Our Ref: 23-003

Town Planning Submission

North Ryde Station Precinct SSD-5093-MOD 6

Figure 8 | Solar analysis of public open space

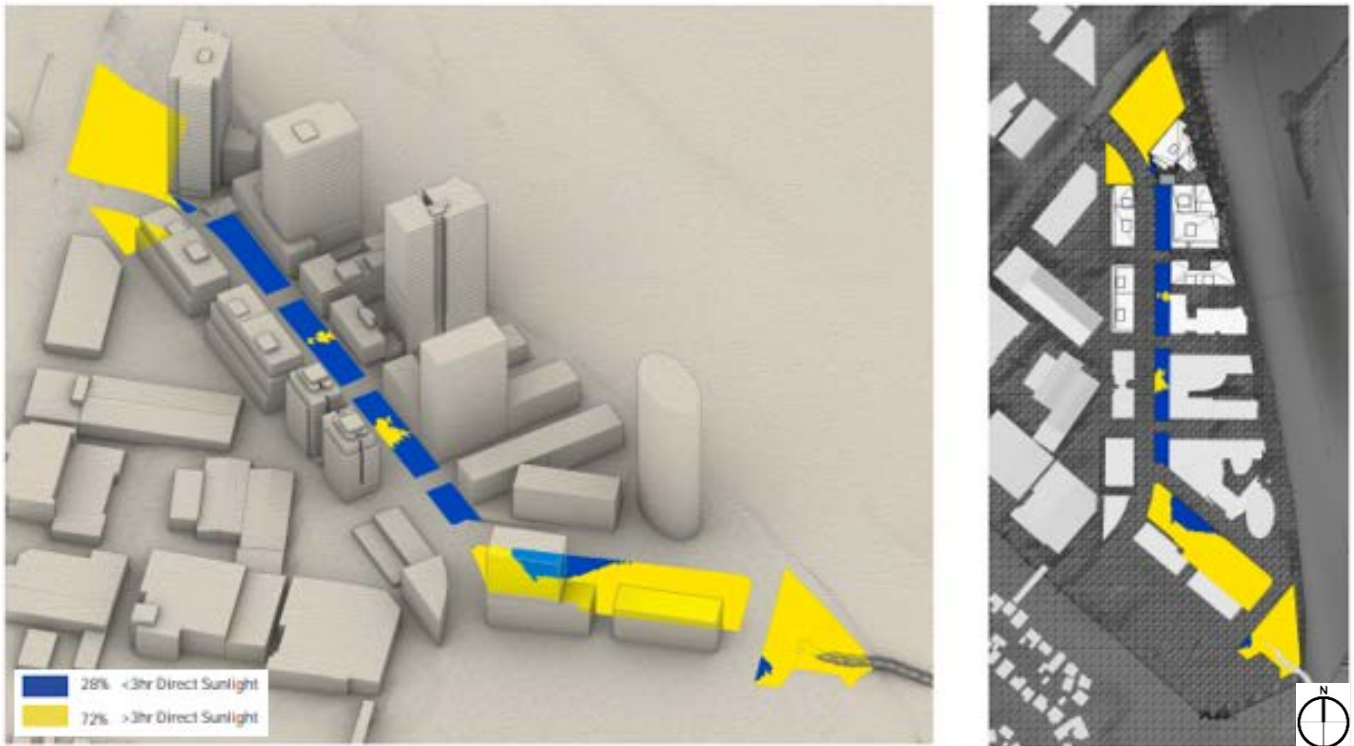
The amended application results in additional overshadowing of the Civic Quarter. The extent of overshadowing is shown at 9am and 10am, as measured on the 21st June (Figure 3) and as measured on 22nd December (Figure 4). We would note that the overshadowing diagrams prepared are not entirely clear when considering the development as approved and as proposed.

Figure 10 | Comparison between overshadowing impacts from the indicative built form envisaged under the Concept Approval (blue) and the proposed modification (green)

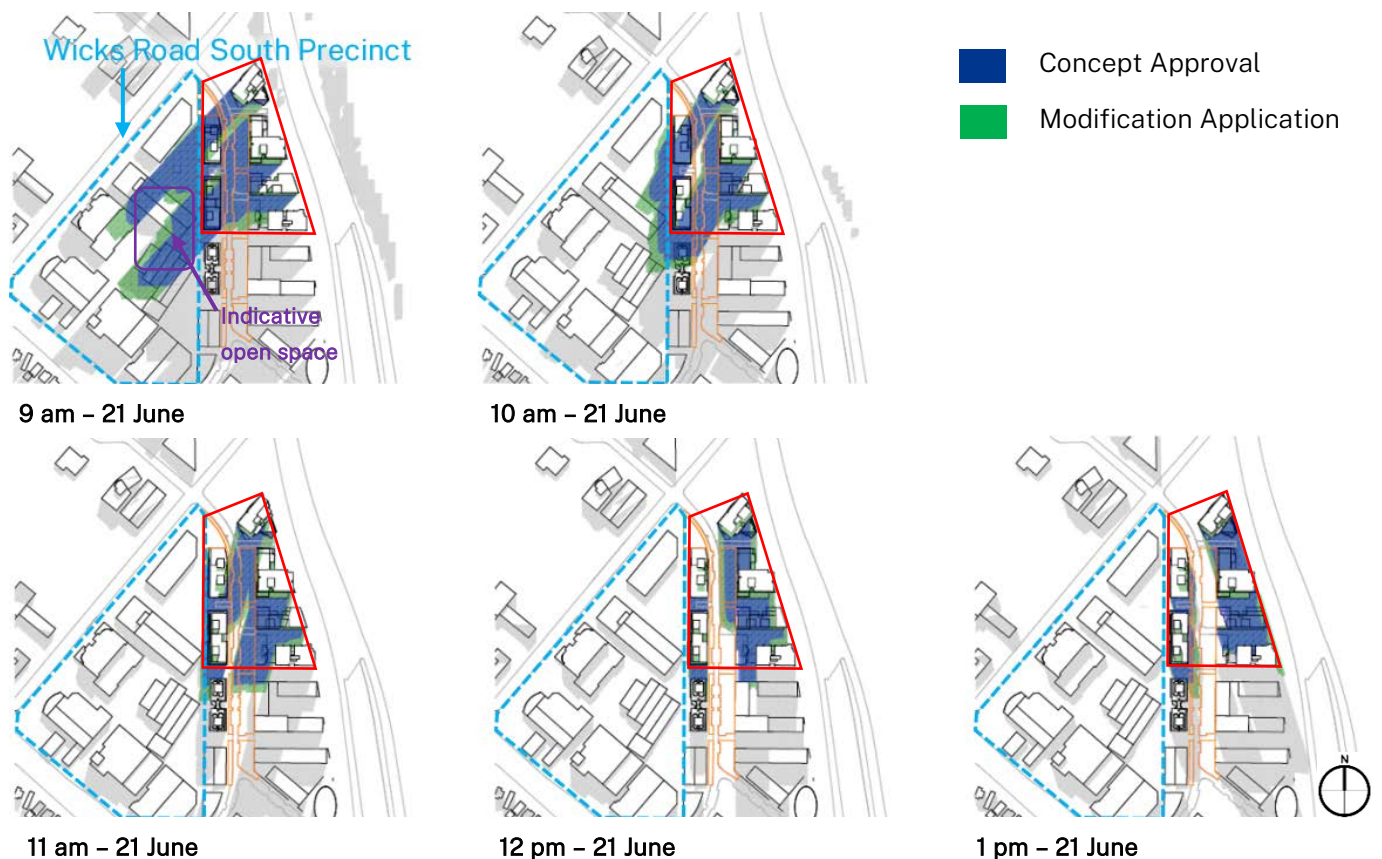
While the rationale behind the re-distribution of the buildings' gross floor area is understood, additional amenity impacts on our clients' land holding is not supported. The onus is on the applicant to ensure no external impacts on neighbouring sites, and we seek confirmation from the Department on how this will be achieved. We note that concept planning undertaken for the Civic Quarter proposes open space in the form of a park and playing fields which is sensitive to overshadowing.
